STATE OF NORTH CAROLINA  
DEPARTMENT OF TRANSPORTATION

**Addendum No. 1**

RE: Contract # C204631

**Henderson County (U-5887)**

UTILITIES BY OTHERS

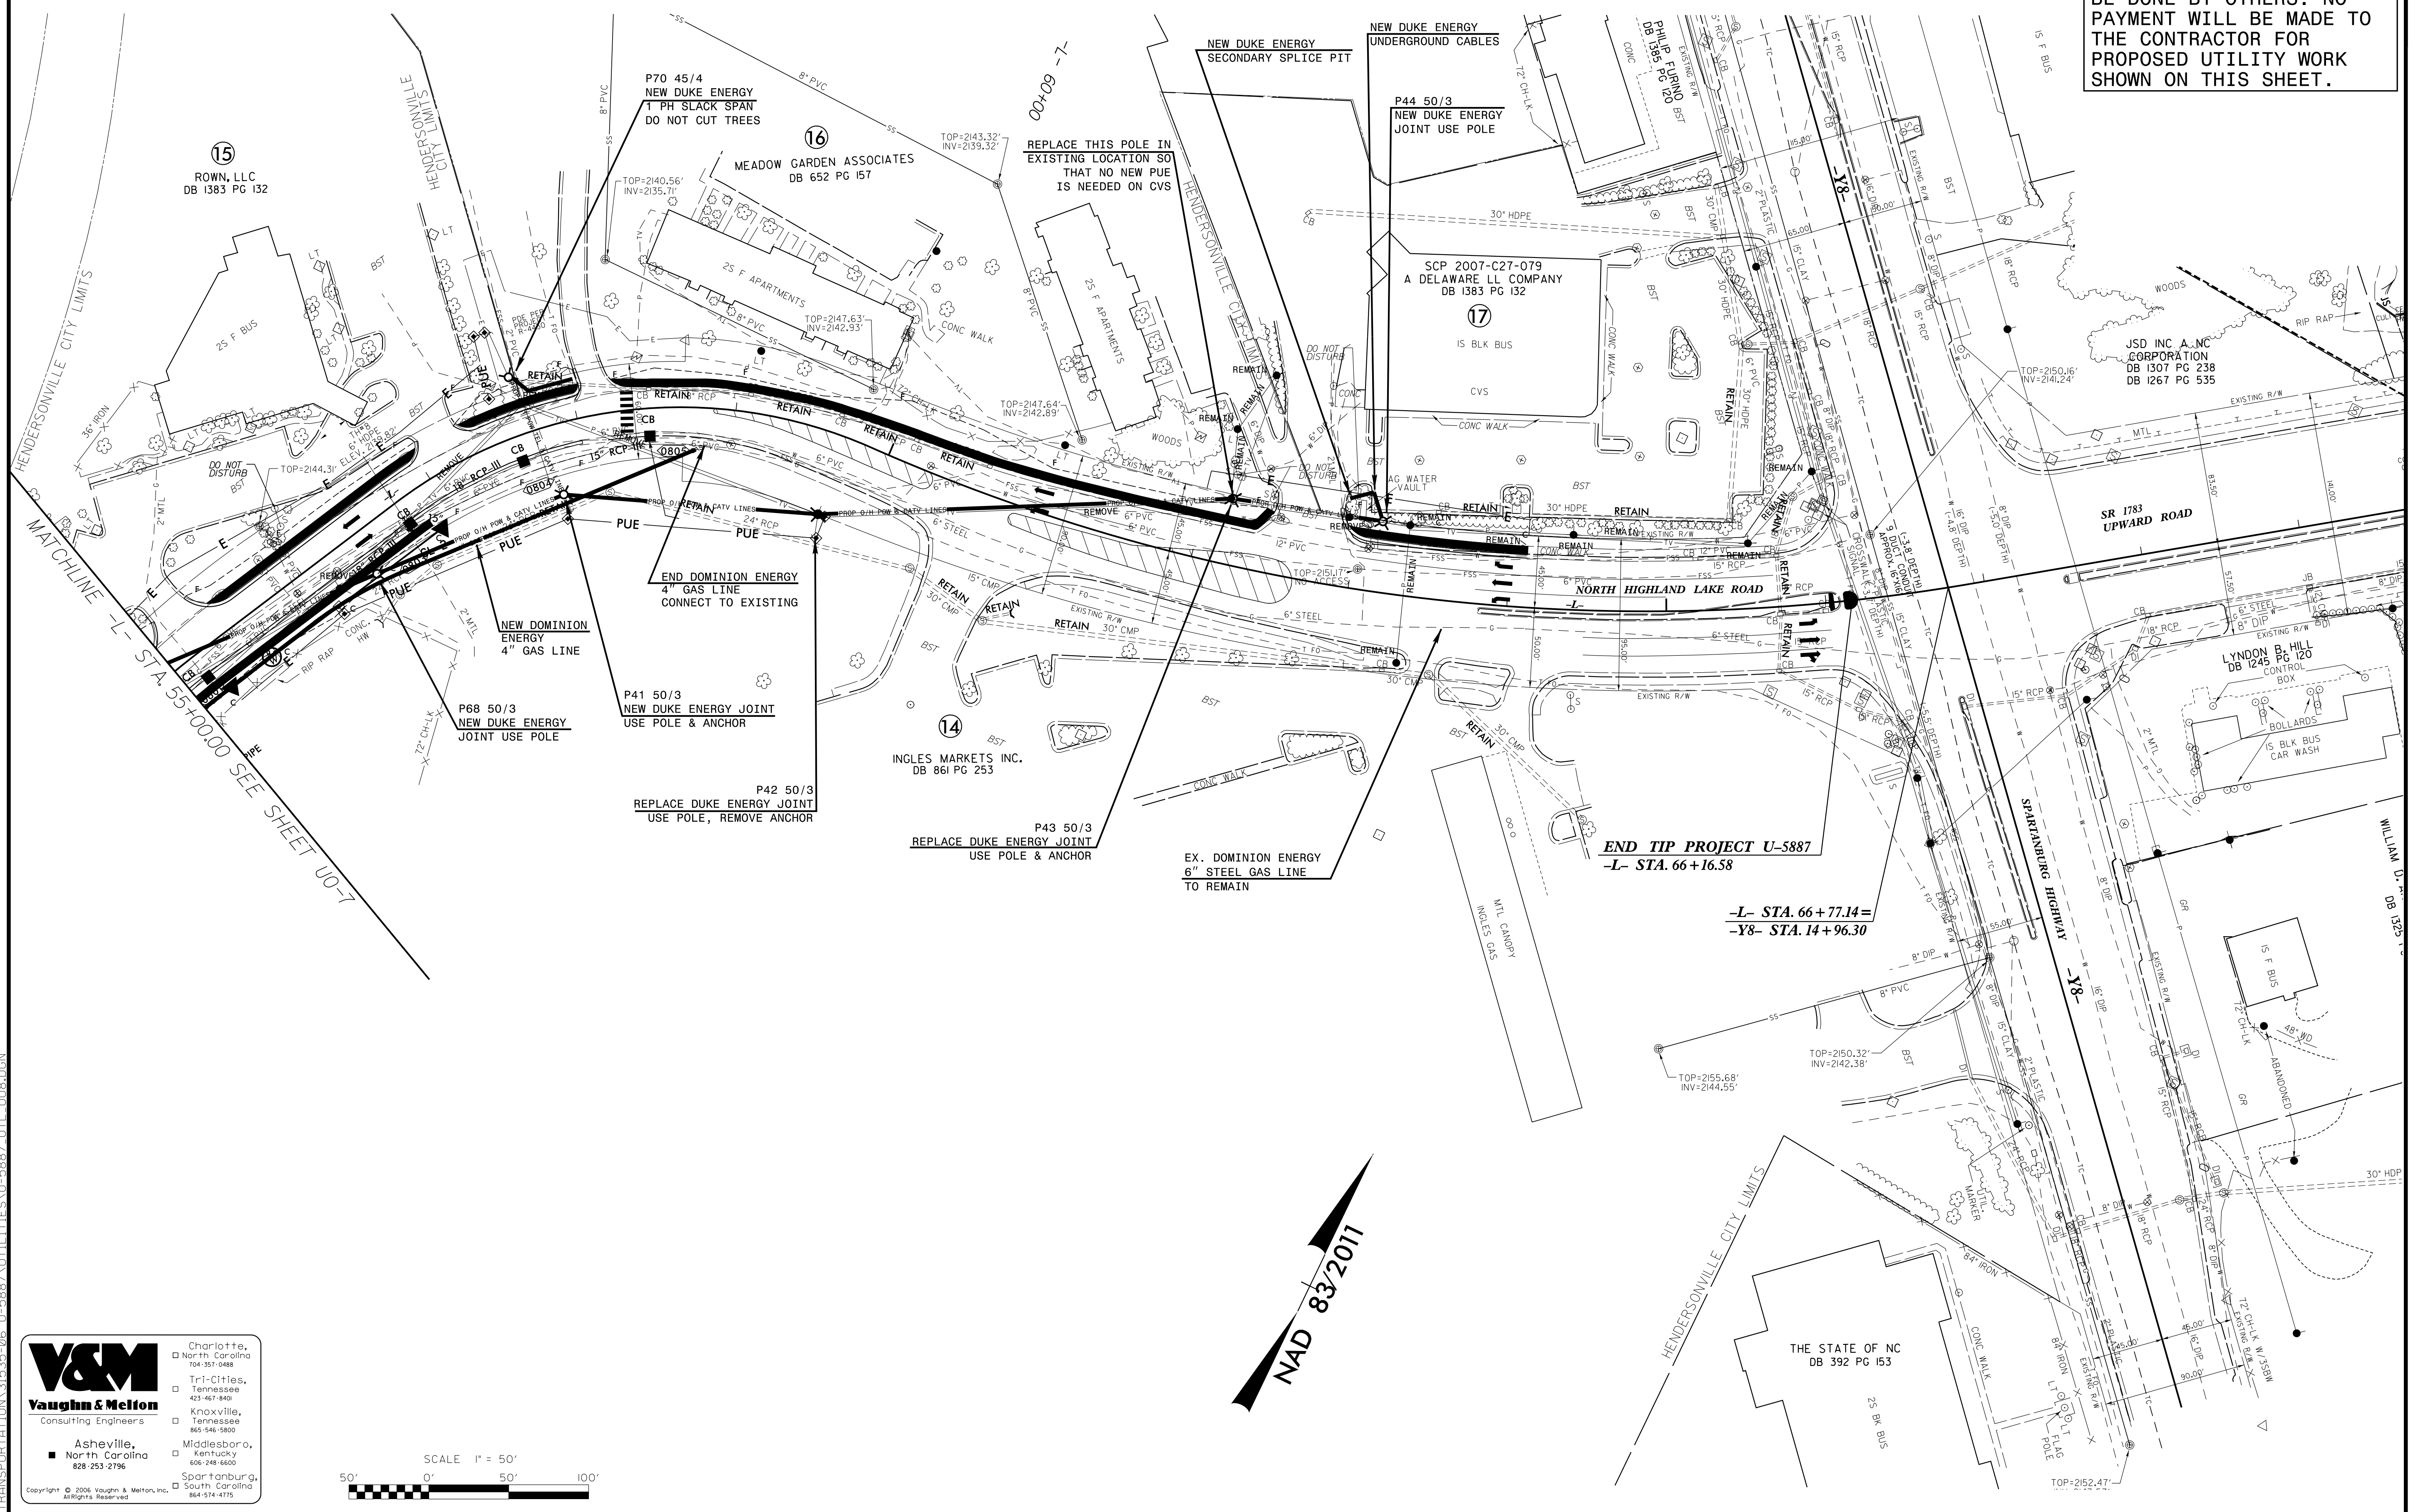
- A. Duke Energy – Power
  - (a) Duke Energy owns and maintains overhead and underground power within the proposed project limits. Duke Energy will remove and install these facilities, in three phases, as shown on UO-4 through UO-8. The anticipated completion date is January 1, 2022.
  - (b) Contact person for Duke Energy is Mr. Bob Mabry, (828) 698-2055.

- B. Dominion Energy – Gas
  - (a) Dominion Energy will install new gas main within the project limits as shown on UO-4 through UO-8, with an anticipated completion date of February 1, 2022.
  - (b) Contact person for Dominion Energy is Ms. Samantha Ward, (704) 810-3216.

- (a) AT&T will relocate their facilities within the project limits as shown on UO-4 through UO-8, with an anticipated completion date of June 1, 2022.
- (b) Contact person for AT&T is Mr. Scott Addington (828) 258-7138.

- (a) Morris Broadband will relocate all underground and aerial cable lines within the project limits as shown on UO-4 through UO-8, with an anticipated completion date of February 1, 2022.
- (b) Contact person for Morris Broadband is Mr. Jasper Duncan, (828) 697-3600.
